**Consultation Response from Mike Hibbert,  
KC Waste Strategy( Refuse & Recycling)**

**2024/91998 former, Almondbury High School, Fernside Avenue, Huddersfield, HD5 8PQ**

**Date Responded: 06/08/2024.**

**Responding Ref: WPS 24-043**

Access and Circulation 1 of 3 - Service & Maintenance

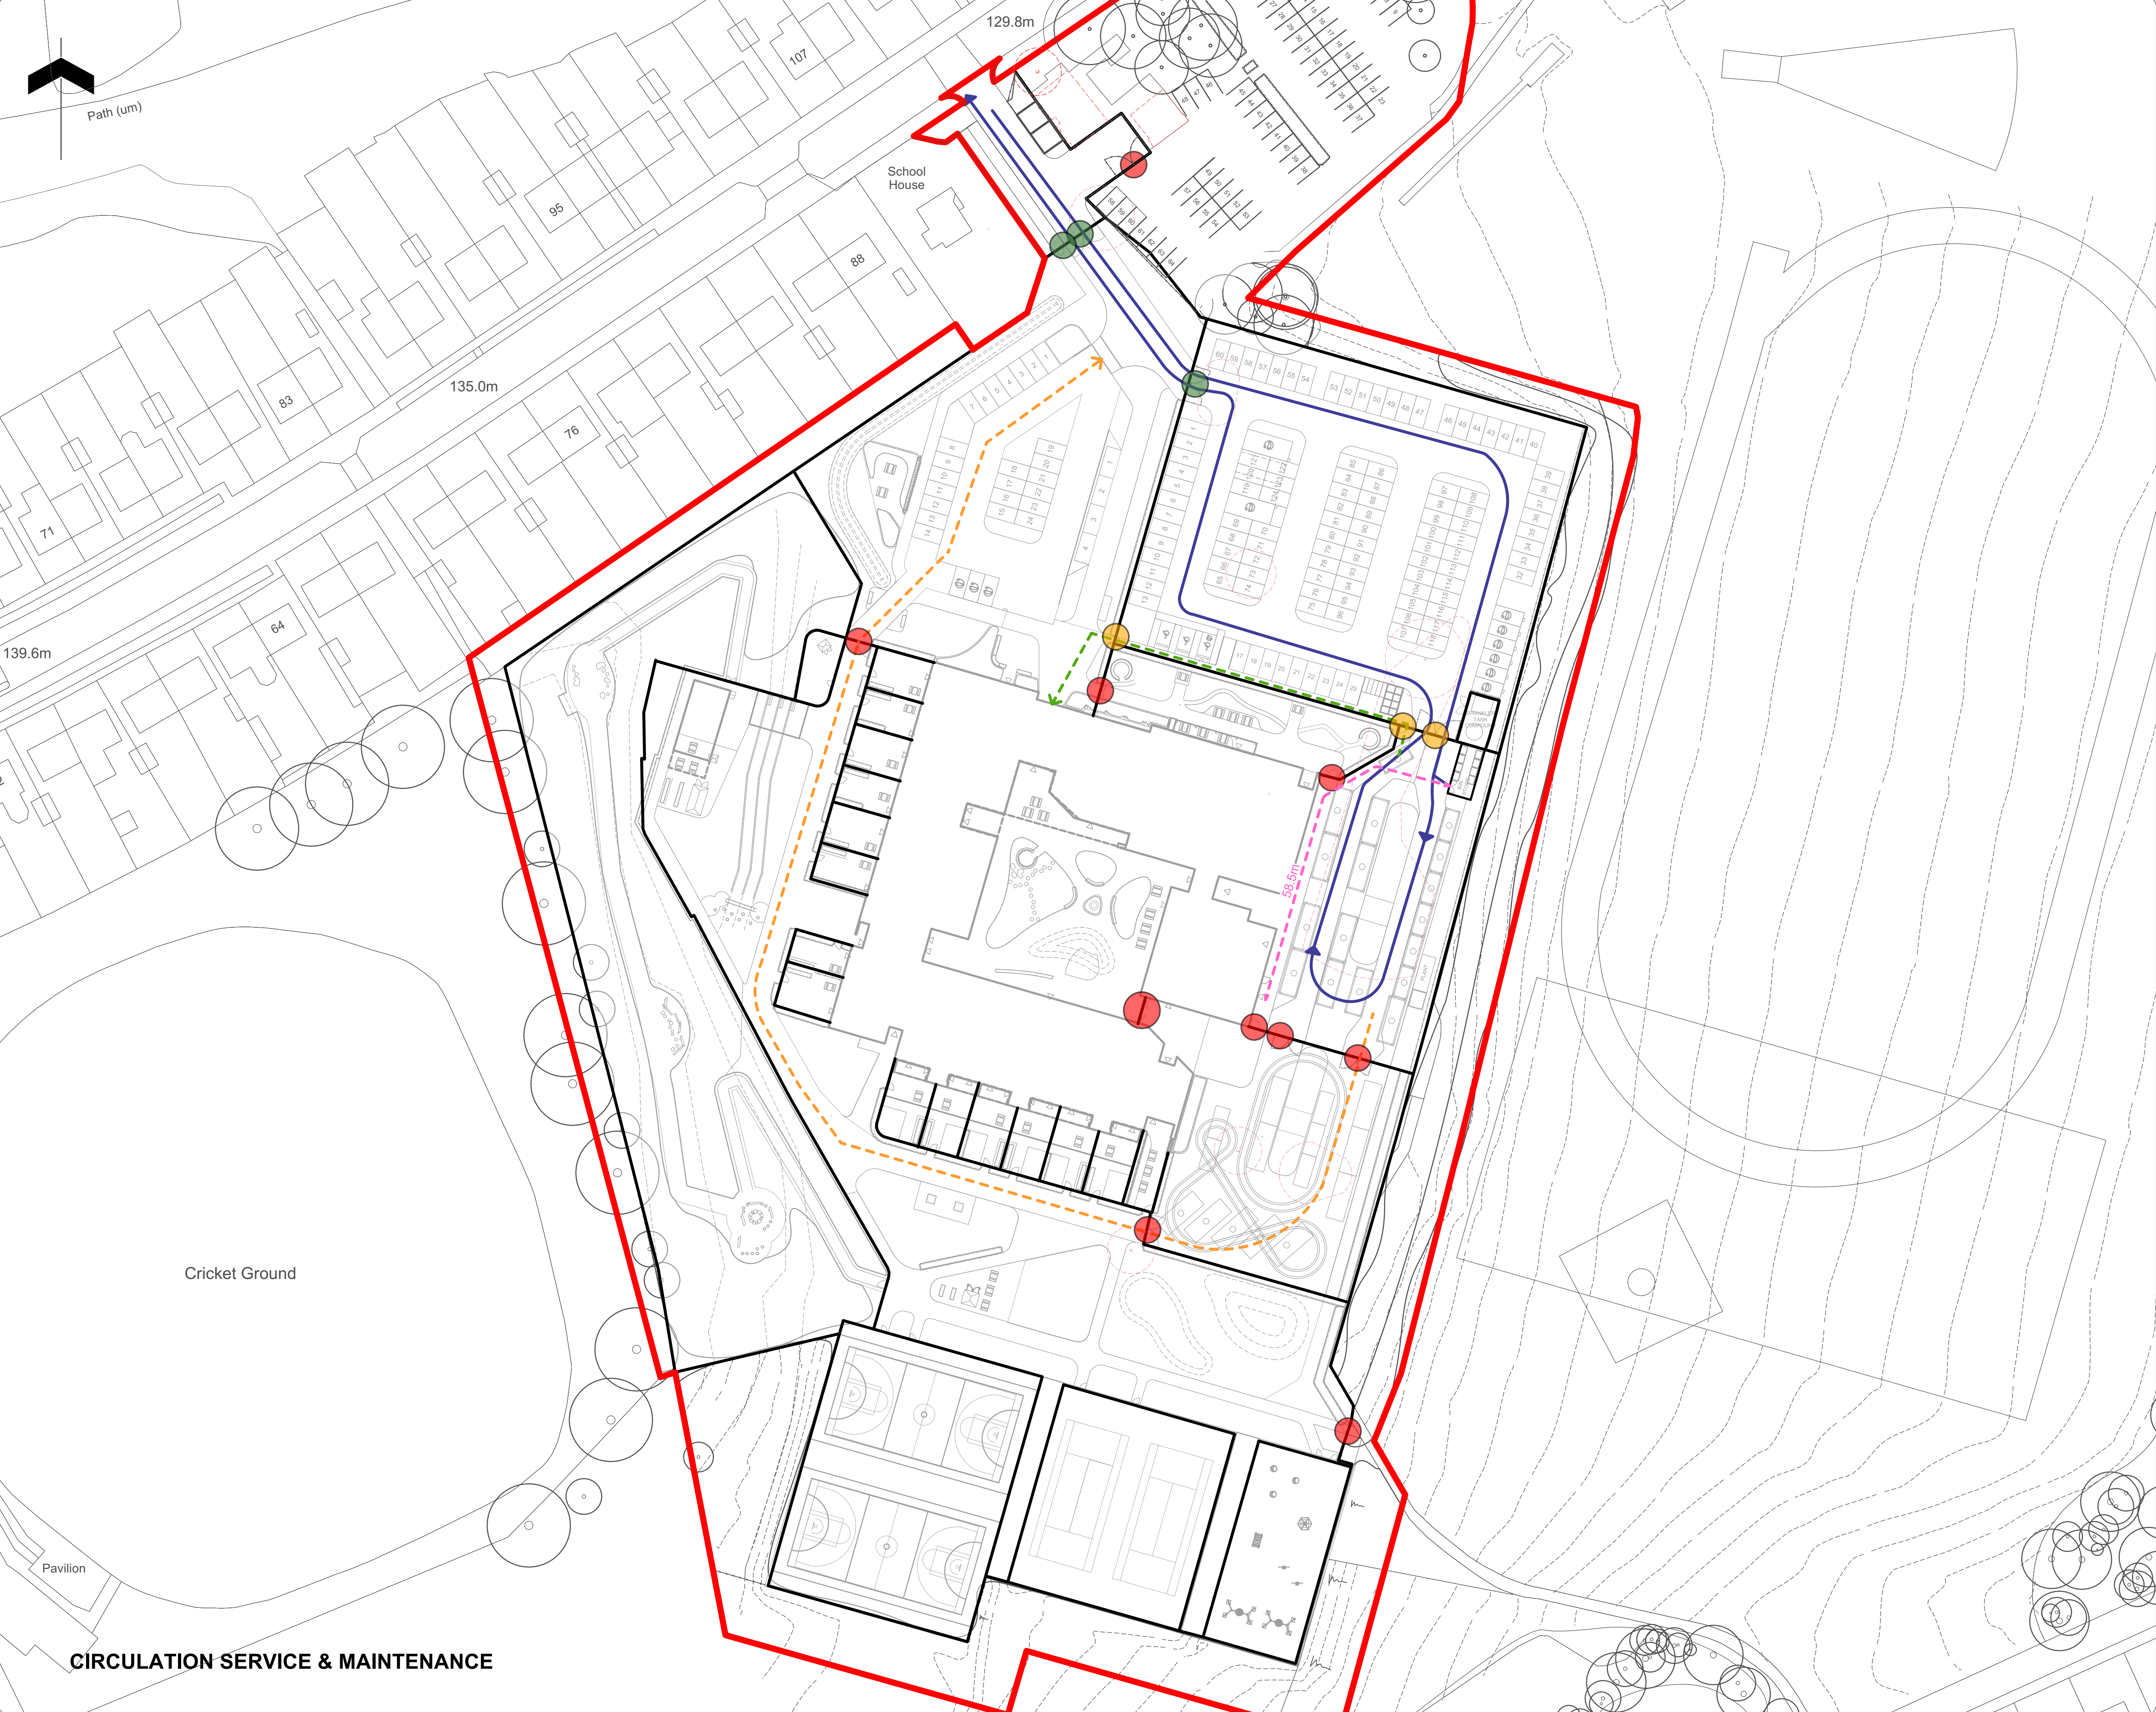
- Consideration should be given to relocating the waste storage area to the proposed location of either the cycle store or sprinkler tank compound as shown on the plan. This may slightly reduce security of the store, but it is still within a fenced / controlled area, and catering / caretaking staff would have to walk slightly further to deposit waste. Relocation of the store would have the advantage of facilitating waste collections without an RCV having to enter the site beyond the car parking area and hence avoid the potential interaction of site staff and pupils with large vehicles.

- The route between the store and bin collection point needs to be a hard smooth surface. The drag out distance for wheeliebins from a Bin store to the collection vehicle should preferably be under 10m and from the proposed plan this does appear to be acceptable.

- The plan shows the access for an RCV as a loop along the service/ delivery yard that avoids the requirement for a reversing manoeuvre that is welcomed.

- Swept path analysis must show the manoeuvrability of this vehicle throughout the site, demonstrating the safe passing of other vehicles likely to be using the access road – either parked or moving. This is a key issue as the RCV will need to pass through carpark areas to get to the service bay/ bin store.

- Parked cars are a perpetual problem for RCV access and as such it is important to account for potential parking spaces, even where these are undefined when assessing RCV access around the site.
